# Taronga Zoo Sky Safari

Appendix J  
BCA / DDA Report

**Taronga Cable Car Sky Safari at Taronga Zoo**

<b>Report Number &amp; Revision:</b>	<b>MSA2409_BCA_TAR_B_3</b>
<b>Prepared For:</b>	<b>Taronga Zoo</b>
<b>Date of Issue:</b>	<b>22.07.2024</b>

Figure 4 Lower station ground floor plan

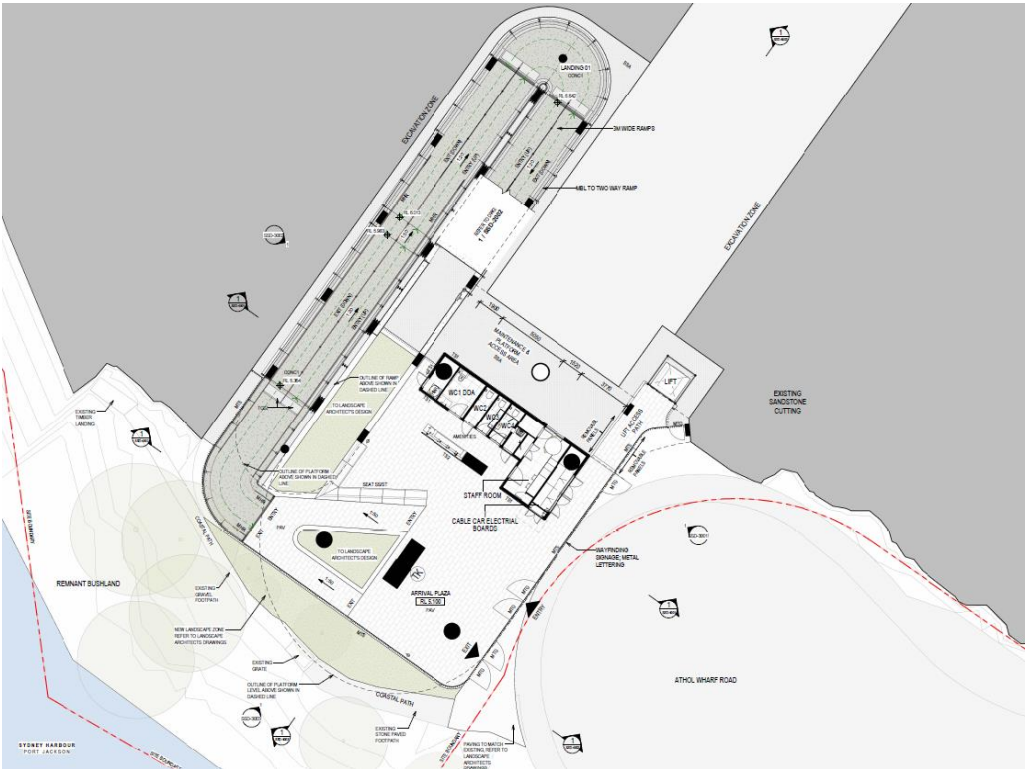
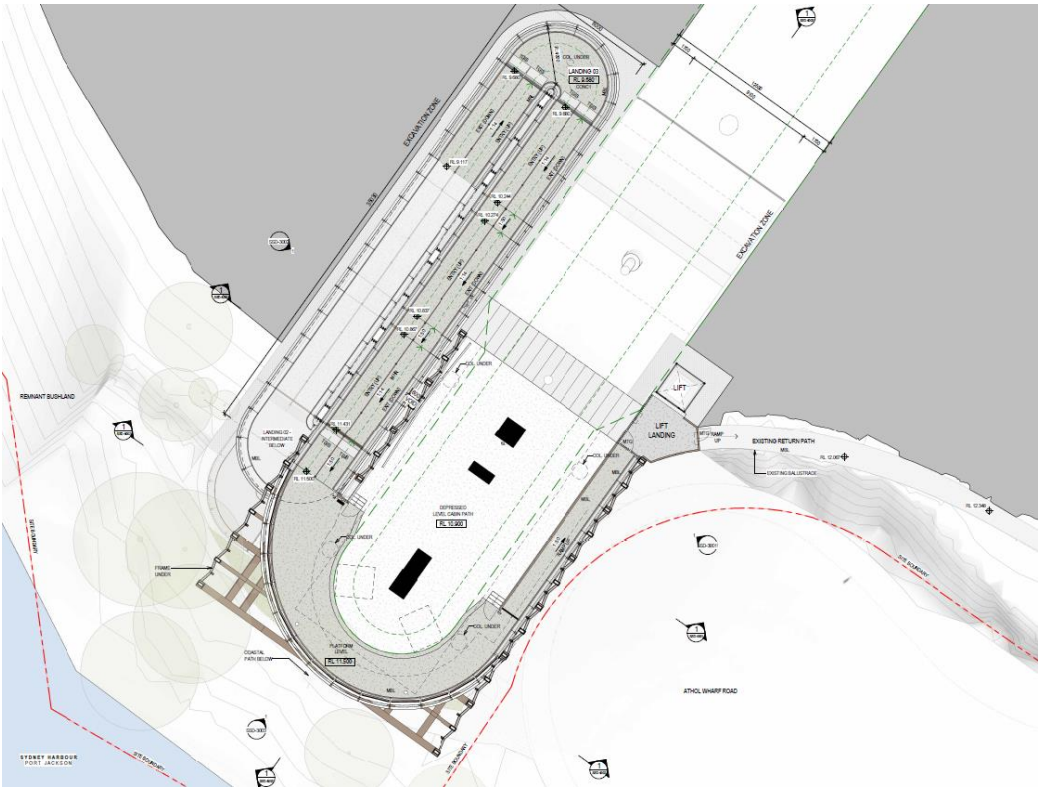
5.	<p><b>Dimensions of Exits &amp; Paths of Travel to Exits</b> – <i>BCA Clause D2D8</i></p> <p>The following areas do not comply with the minimum dimensions of exits &amp;/or aggregate exit width required under BCA <i>D2D8</i>:</p> <ul style="list-style-type: none"> <li><b>‘BOTTOM’ Station Platform Level</b> - Egress from the platform area only appears possible via 1 non-fire-isolated ramp. Further details/clarification from the design team will be necessary to determine adequate Exit Width vs Population load from this area.</li> </ul>	Further Detail Required

6.	<p><b>Travel Via Non-Fire Isolated Ramp</b> – <i>BCA Clause D2D14</i></p> <p>The following areas do not comply with the requirements of BCA Clause D2D14 as:</p> <ul style="list-style-type: none"> <li><b>‘BOTTOM’ Station Platform Level</b> – Egress via the non-fire-isolated ramp from platform level exceeds 80m to a road or open space and will require to be performance justified via a fire engineered performance solution.</li> </ul>	Fire Engineering
Part D4 “Access for People with Disabilities”

8.	<p><b>Ramps</b> - <i>BCA Clause D4D12 and I2D3</i></p> <p>The proposed ramps serving the buildings contain the following accessibility compliance issues:</p> <ul style="list-style-type: none"> <li><b>‘BOTTOM’ Station Total RL Change</b> - incorporates a series of ramps which exceeds the maximum permitted combined vertical rise of 3.6m under BCA D4D12 (Approx 6.5m total RL change). Ramps are required to be designed to ensure that they do not cause undue fatigue for a user to the point where the ramp becomes unusable. Mindful of the above, we note that the SSDA Plans have been modified and illustrates a proposed lift that may assist in providing an accessible path of travel. Further details are necessary to understand its purpose and operation (ie is it intended to act as an alternative accessible path to the series of ramps for those who need it, is it for public use for all passengers and how is it accessed / who is allowed to access it etc).</li> <li><b>Ramp Landing Spacings</b> – The proposed landing spacings for the ramps were not clearly indicated on the plan. According to AS1428.1, up to 9m spacing is allowed, with 6m recommended for best practice as intended under BCA Part I2 (DSAPT). Further design discussions will be necessary as the design progresses.</li> </ul>	<p>DOES NOT COMPLY</p> <p>Further Detail Required</p>
